Address: 2 Pennine Gardens Holmfirth HD9 3FA

Application number: 2022/92799	
What is the application for?:	Erection of extensions, conversion of existing attached barn to living accommoda
Address of the site or building:	17, Town Gate, Upperthong, Holmfirth, HD9 3UX
Postcode:	HD9 3UX

REV	DATE	DESCRIPTION
PROJECT		
17 TOWNGATE, UPPERTHONG		
TITLE		
VEHICLE TRACKING - CAR		
SCALE		
1:200 @ A3		
DRAWING		
2063-101		
DATE		
07.07.2022

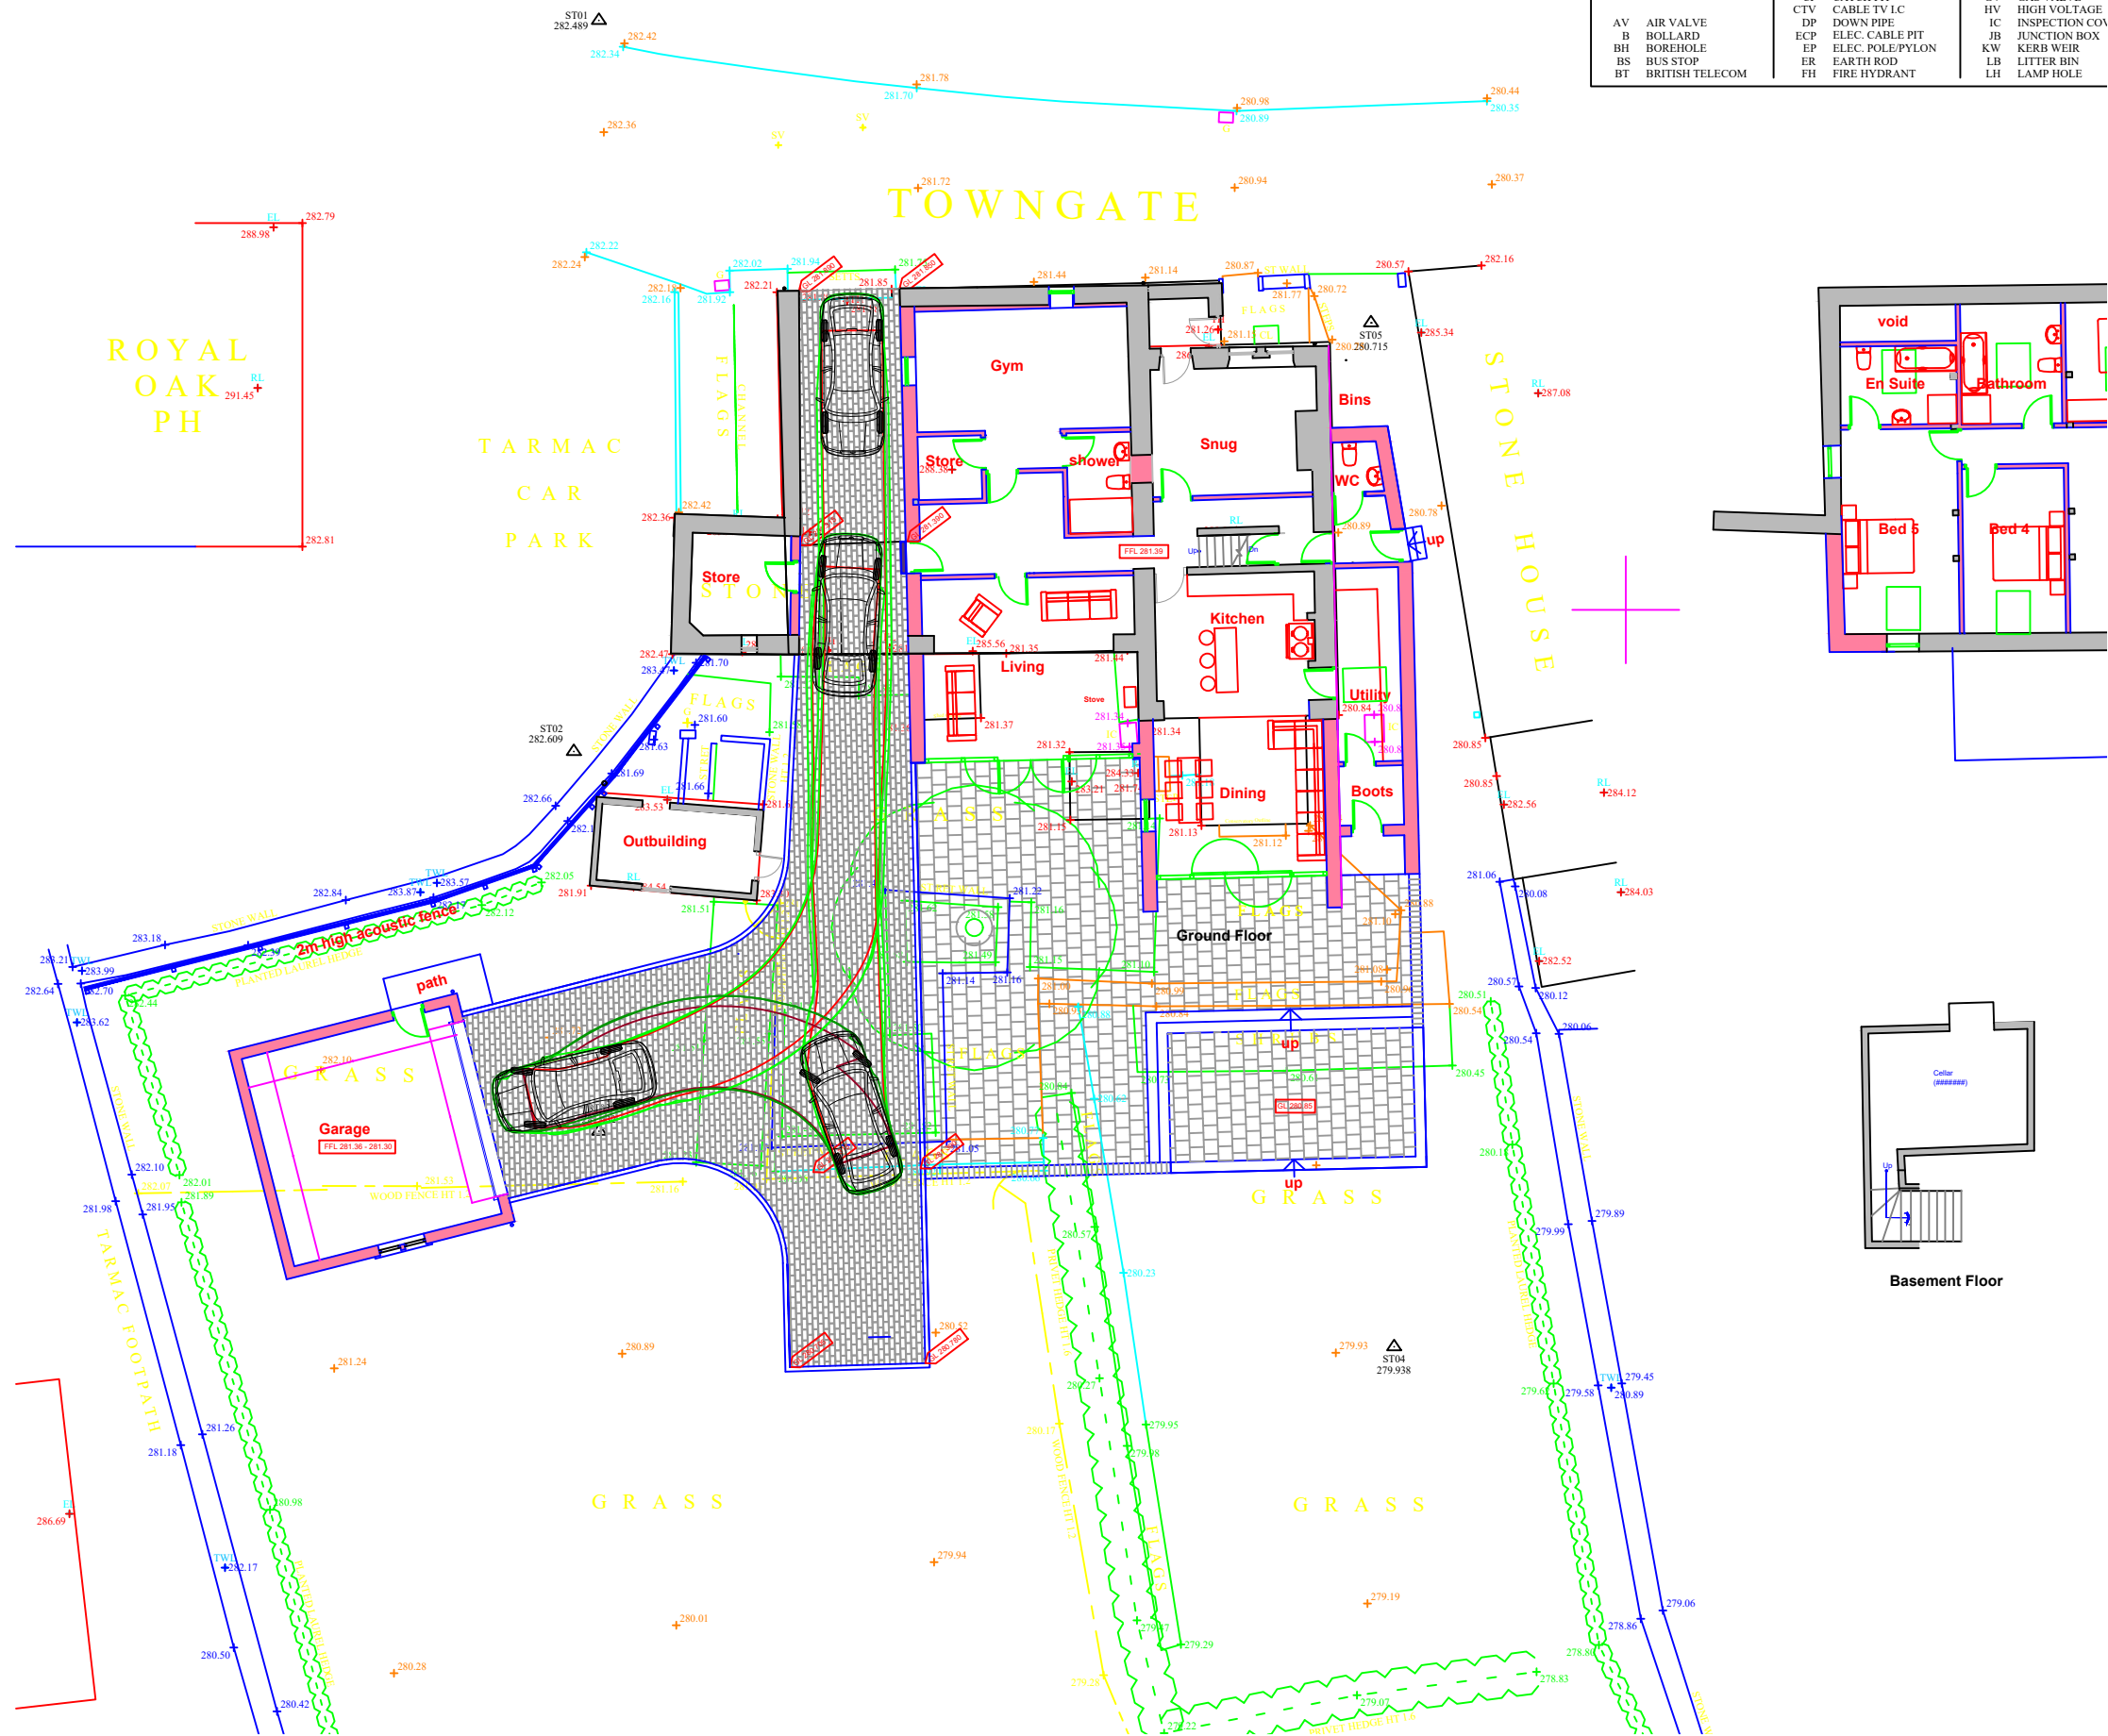
Type of comment: An objection	
Do you wish your comments to be published on the website anonymously?	No
1. ACCESS. The opening up of the existing barn access as a thoroughfare seems unsafe. I note the highways assessment by Paragon does not include any visibility splays which is commonplace with other applications such as this. The general requirement is for a 1.5m x 1.5m clear visibility at a height above 600mm to be achieved either by widening the proposed access or splaying back the abutting wall or building. Given the position of the access is at the boundary of the property this does not seem achievable. In addition there are regularly cars parked opposite the barn door and I don't see how a typical vehicle could manoeuvre in and out of this access point without further modification. Furthermore the existing access to the rear on the east elevation of the property seems to be wider and a safer proposition requiring little to no modification of the existng street scene. There is even an existing five bar gate to permit vehicular access. I also note with interest that the assessment document submitted from Paragon states in section 2.3 that "It is acknowledged that the existing access to the garage falls short of current standards". If dramatic redevelopment of this site is to be permitted then surely the access to said site should be brought in line with current standards. 2. NEW WALL. The proposed 1.8m (6ft) wall along the boundary is specified above the level of the Royal Oak Public House car park. The applicant's land is significantly lower than this level meaning the overall wall will be considerably more than 1.8m. I don't see any structural plans for said wall nor any consideration to the footings and containment of land mass which makes up the public house car park itself. In addition, a comment in support of the application states that a 6ft stone wall is commonplace in this area. Having lived in Upperthong for several years and having walked by dog regularly around the local countryside, I have never seen such a wall. It will without question look out of place and incongruous to the venacular of the Upperthong conservation area within which the site sits. Lastly, the loss of amenity view from the public house beer garden, which I frequently visit, will be of detrimental impact to the village and the ongoing success of the Royal Oak as a going concern. 3. PROPOSED REAR ELEVATION. The increase of windows and sloping features to

17 Towngate Proposed Elevations

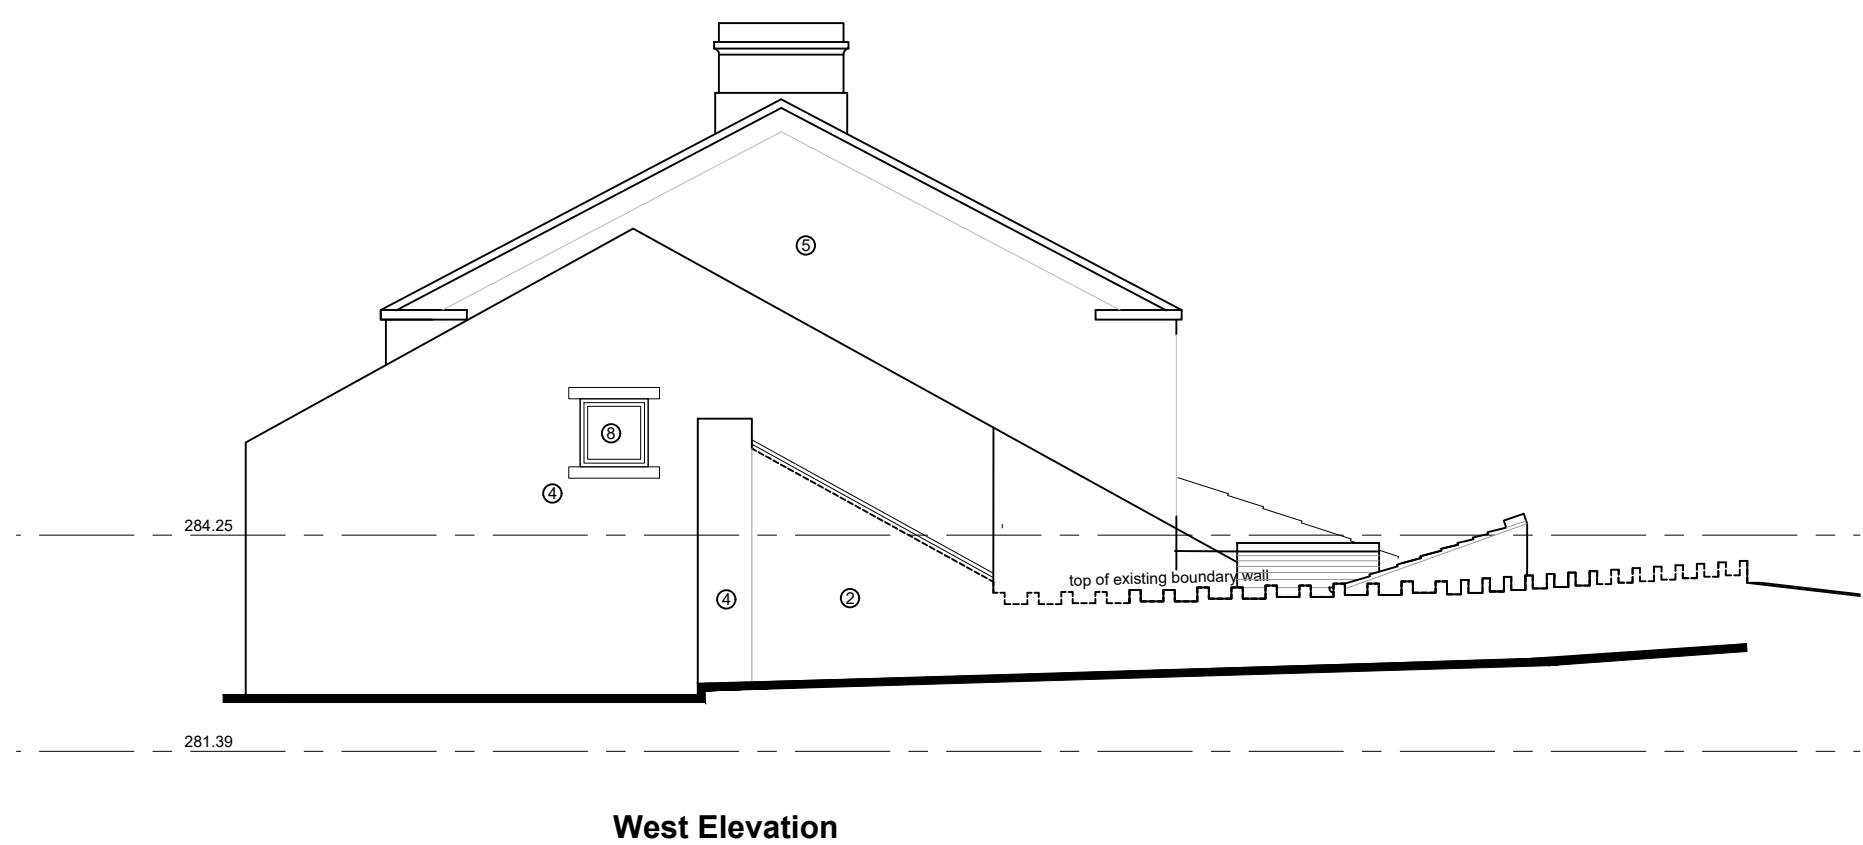
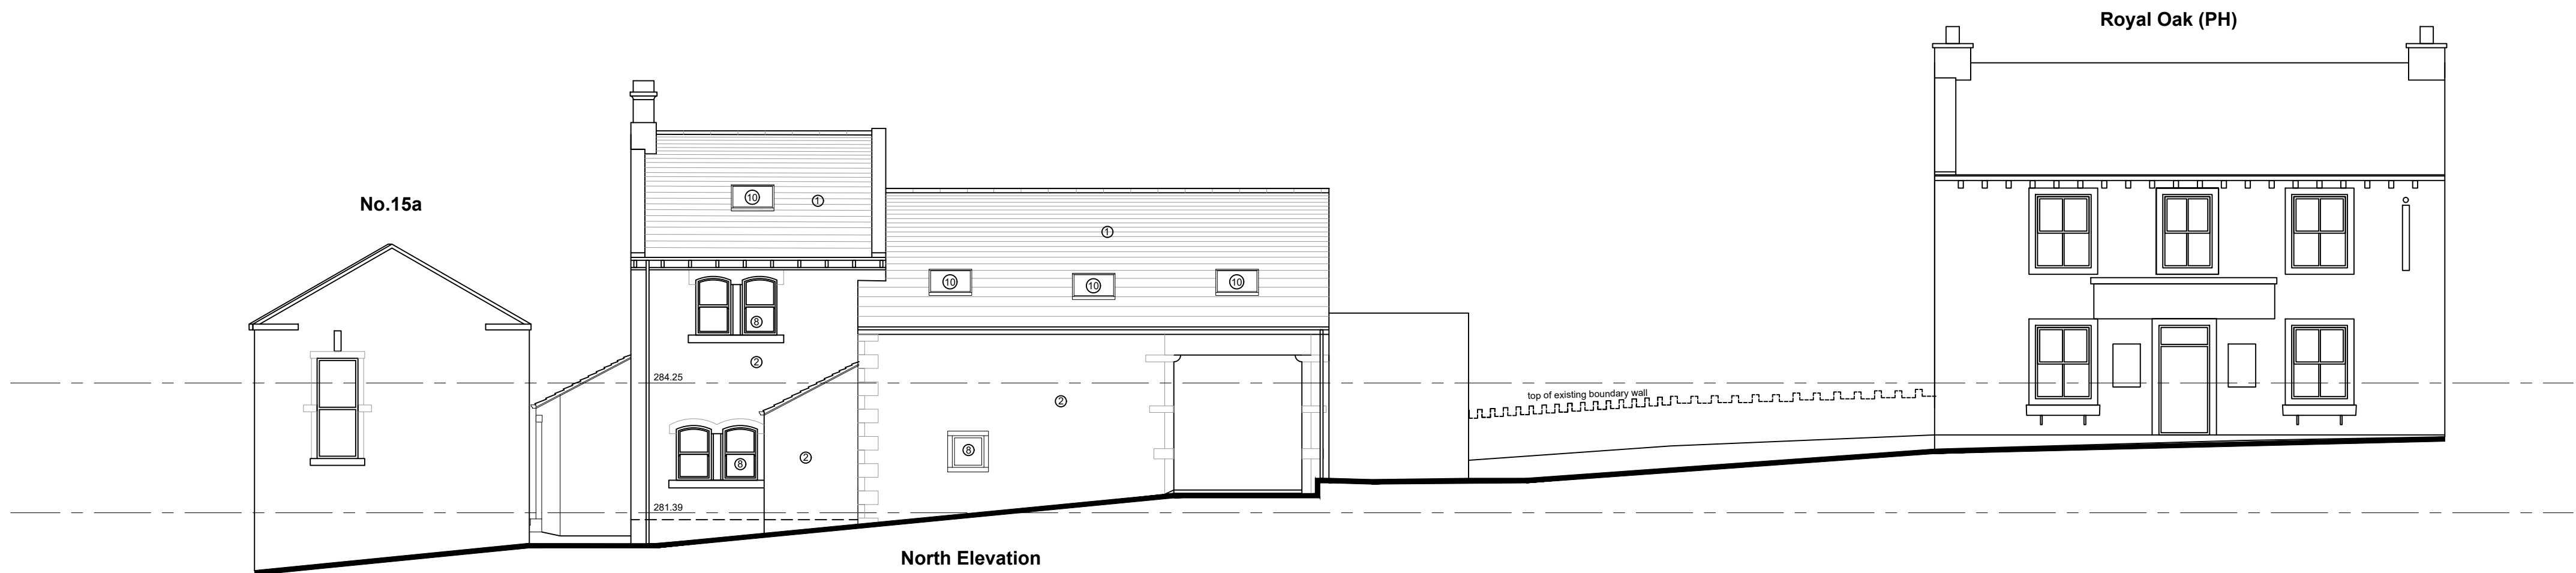
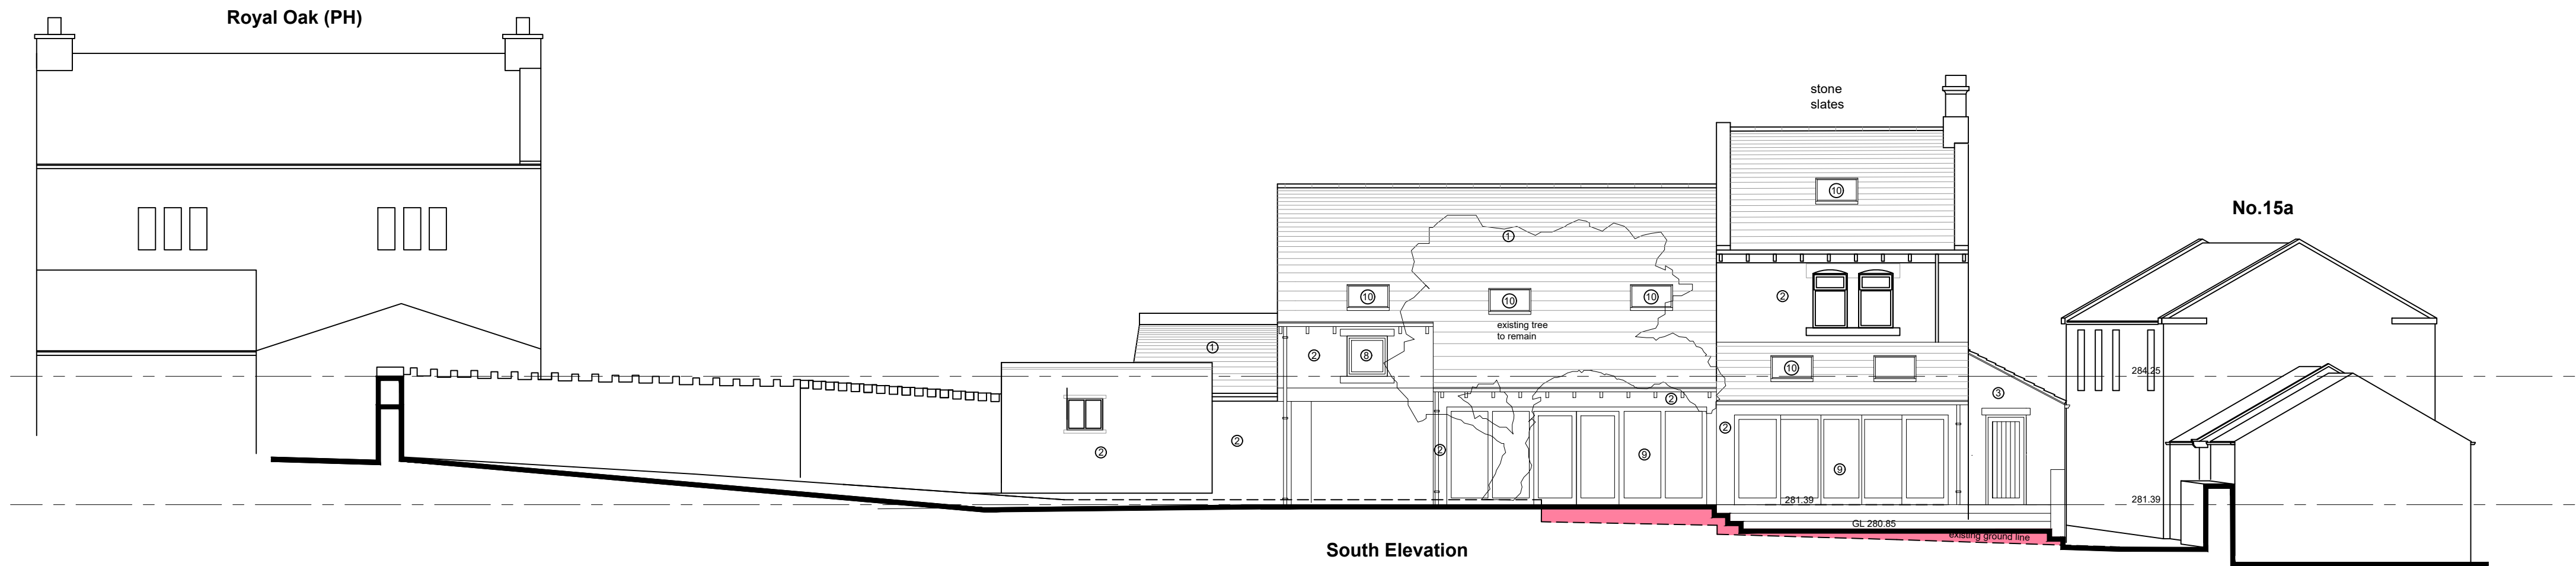
3. PROPOSED REAR ELEVATION. The increase of windows and glazing features to the rear of the property is surely out of kilter with the properties in the local area and not what one would expect to see from such a visible property within a conservation area. With the exception of the lean-to stone store the entire rear elevation shows floor to ceiling glass, be it bifold doors or windows. This is a dramatic and unnecessary change from the existing elevation.
